Our reference: DOC14/233758

**Refusal to grant General Terms of Approval - Additional information required in EIS
Kings Park Waste Metal Recovery, Processing and Recycling Facility (SSD-5041)
23-43 and 45 Tattersall Road, Blacktown**

ATTACHMENT 1

Figure 4.4 Location of the point and volume sources modelled

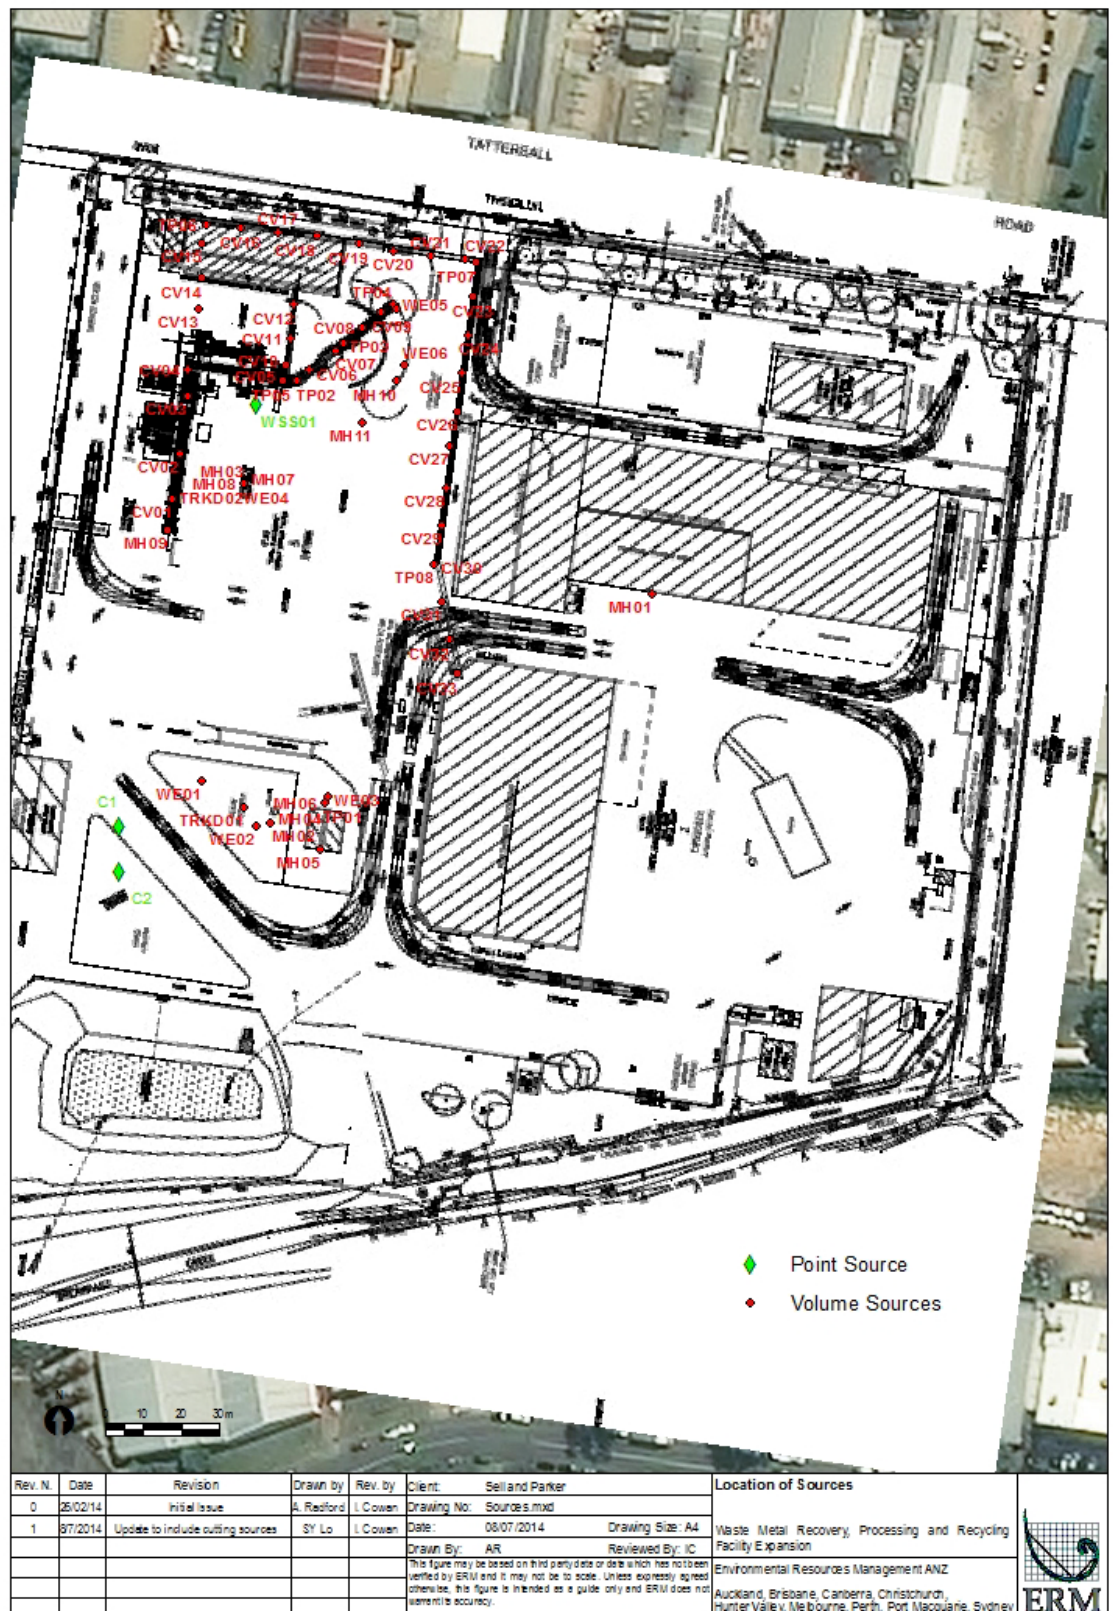
The hammermill was labelled as the wet scrubber in the Air Quality Assessment (AQA) and characterised as a stack source with a diameter of 0.56 m and a height of 3 m. Photos were provided by the proponent showing the vent where odour monitoring was completed. From the photos provided, the hammermill appears to be near the incline conveyor (CV04). However, the location of the discharge stack (WSS01) modelled appears to be near the non-ferrous material drop area (TP05).

It is uncertain whether the location of the hammermill where odour monitoring was undertaken is the same as the wet scrubber stack in the modelling. Therefore, the wet scrubber stack specifications for volumetric flow rate and particulate emission concentration used in the modelling may not be appropriate.

EPA requires the Proponent to provide clarification that the characterisation and the emission rates used in the modelling for the wet scrubber is representative of the hammermill.

Figure B.7 Maximum predicted (over five years) Site contribution to hourly average NO₂ concentrations (excluding background)

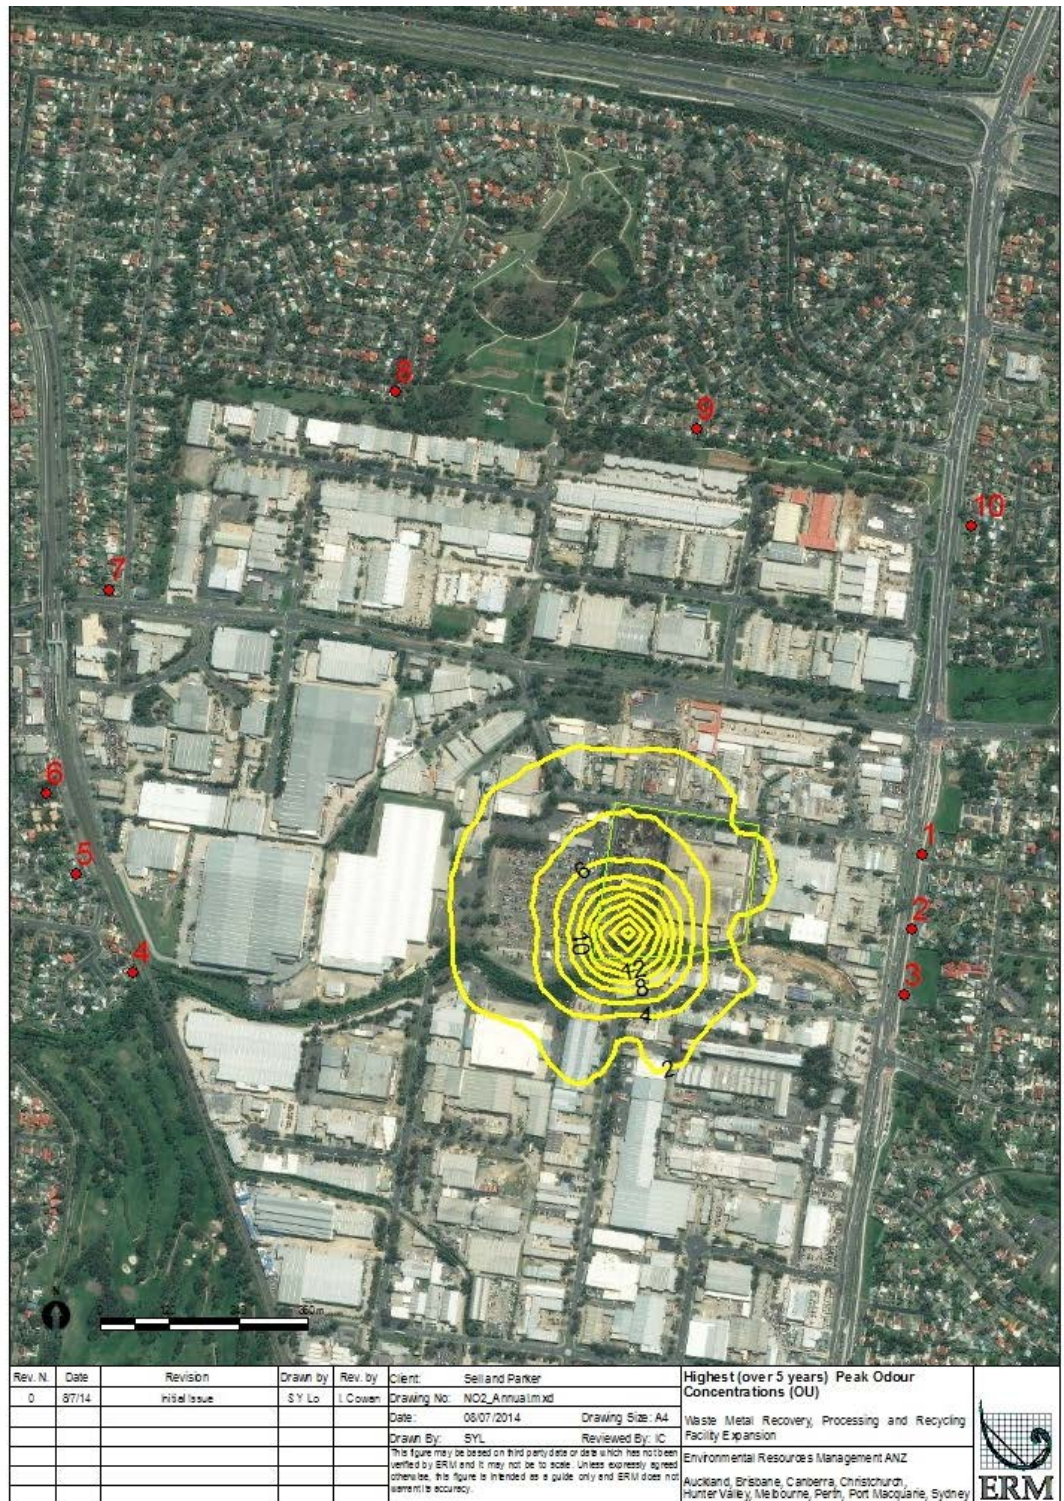
The results of the oxy cutting modelling indicate that the maximum concentration contours for 1-hour average NO₂, iron oxide fumes, manganese and copper dust appears to be on the adjacent site approximately 200 m west of the oxy cutting sources. The contours appear to go around the area where the oxy cutting source is located. There appears to be incongruities in the characterisation of the oxy cutting source for fugitive emissions to accumulate on the adjacent site, 200 m from the source.

Whilst it is agreed that it is difficult to characterise a fugitive emission source like the oxy cutting process, based on the incongruities in the results of the modelling EPA requires the Proponent to undertake sensitivity testing of oxy cutting in the modelling for validation.
